From: Hannah Kersley
Sent: 15 April 2026 16:13
To: Planning.Responses
Subject: Fw: Proposed Care Home at Pine Marten Close, P/25/26/DOC Our Ref: 2324(03.15)

**Approval of details reserved by condition under P/92/25/S73 relating to condition 5- Noise
Kingfisher Manor Pine Marten Close Pagham Bognor Regis PO21 3WE**

PAPER SIZE	A0	SCALE	1:100	DATE	Sept 24
DRAWING NUMBER	2324-200	REVISION	B

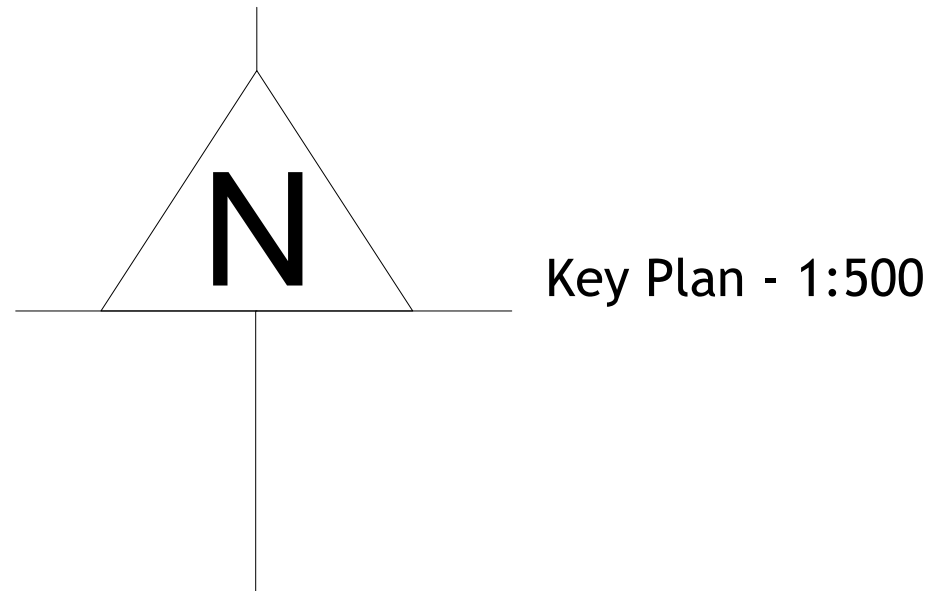
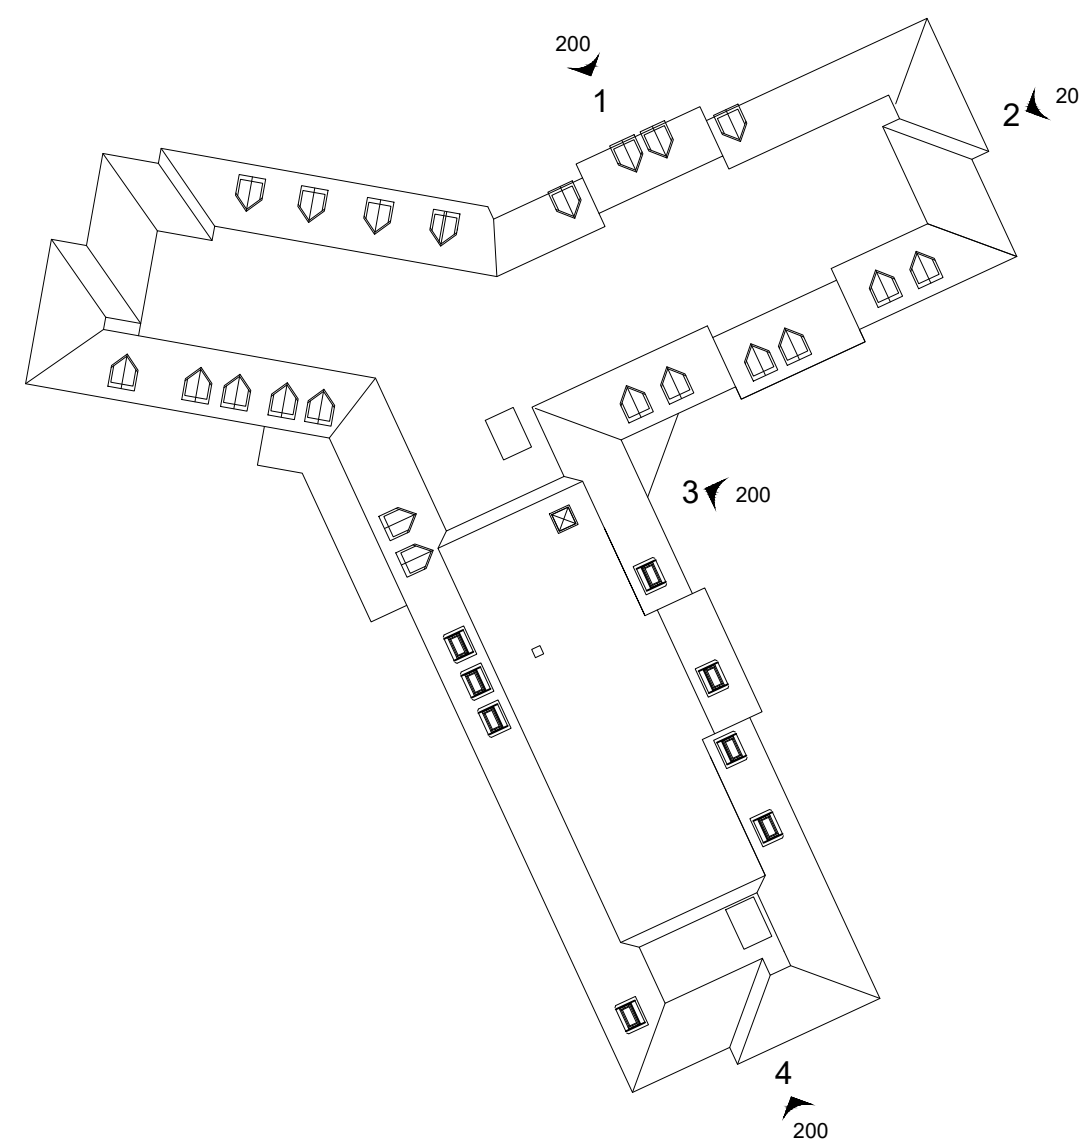
Regarding the above application, I understand that you had a chat with Evan in relation to the VRF units at the south gable of the care home.

We were wondering if it would be acceptable to substitute the noise plan and submit the attached site plan (for the proposed re-location of the VRF units from the ASHP compound to the south gable) so it can be assessed under this discharge of condition application?

In theory this will not be an issue. As I have discussed with Evan, I was looking into whether the relocation of the VRF units could be resolved through a joint NMA and DOC route. As P/25/26/DOC still has a month or so left until expiry, we are in a position to be able to accept the revised noise assessment and any updated plans in respect of discharging condition 5 under this application. On review of the attached and that already submitted, I am happy to accept the amended site plan as a substitute, however I believe we will also need a revised ASHP compound drawing, showing this compound with the VRFs removed. If you are able to get this drawing amended and sent over, I can get this superseded on the application and reconsult environmental health.

However, in order to determine P/25/26/DOC, we do need to make sure that the details we approve as part of the condition are in accordance with the approved plans for the permission. Therefore, to approve the updated NIA and site plan as part of the details for condition 5, we will need an NMA to be submitted and determined before the DOC is determined, so that the condition details match the approved plans. When I last spoke to Evan, I had advised that I was going to go away to check the EHO was happy with the revised NIA, so that we were able to go down the NMA route without requiring an EH consultation. Our EHO has come back to me and confirmed he has no objection with the relocation of the VRFs, and as such we have sufficient clarity that there would be no increased harm to residential amenity from noise pollution, and can confirm an NMA is appropriate.
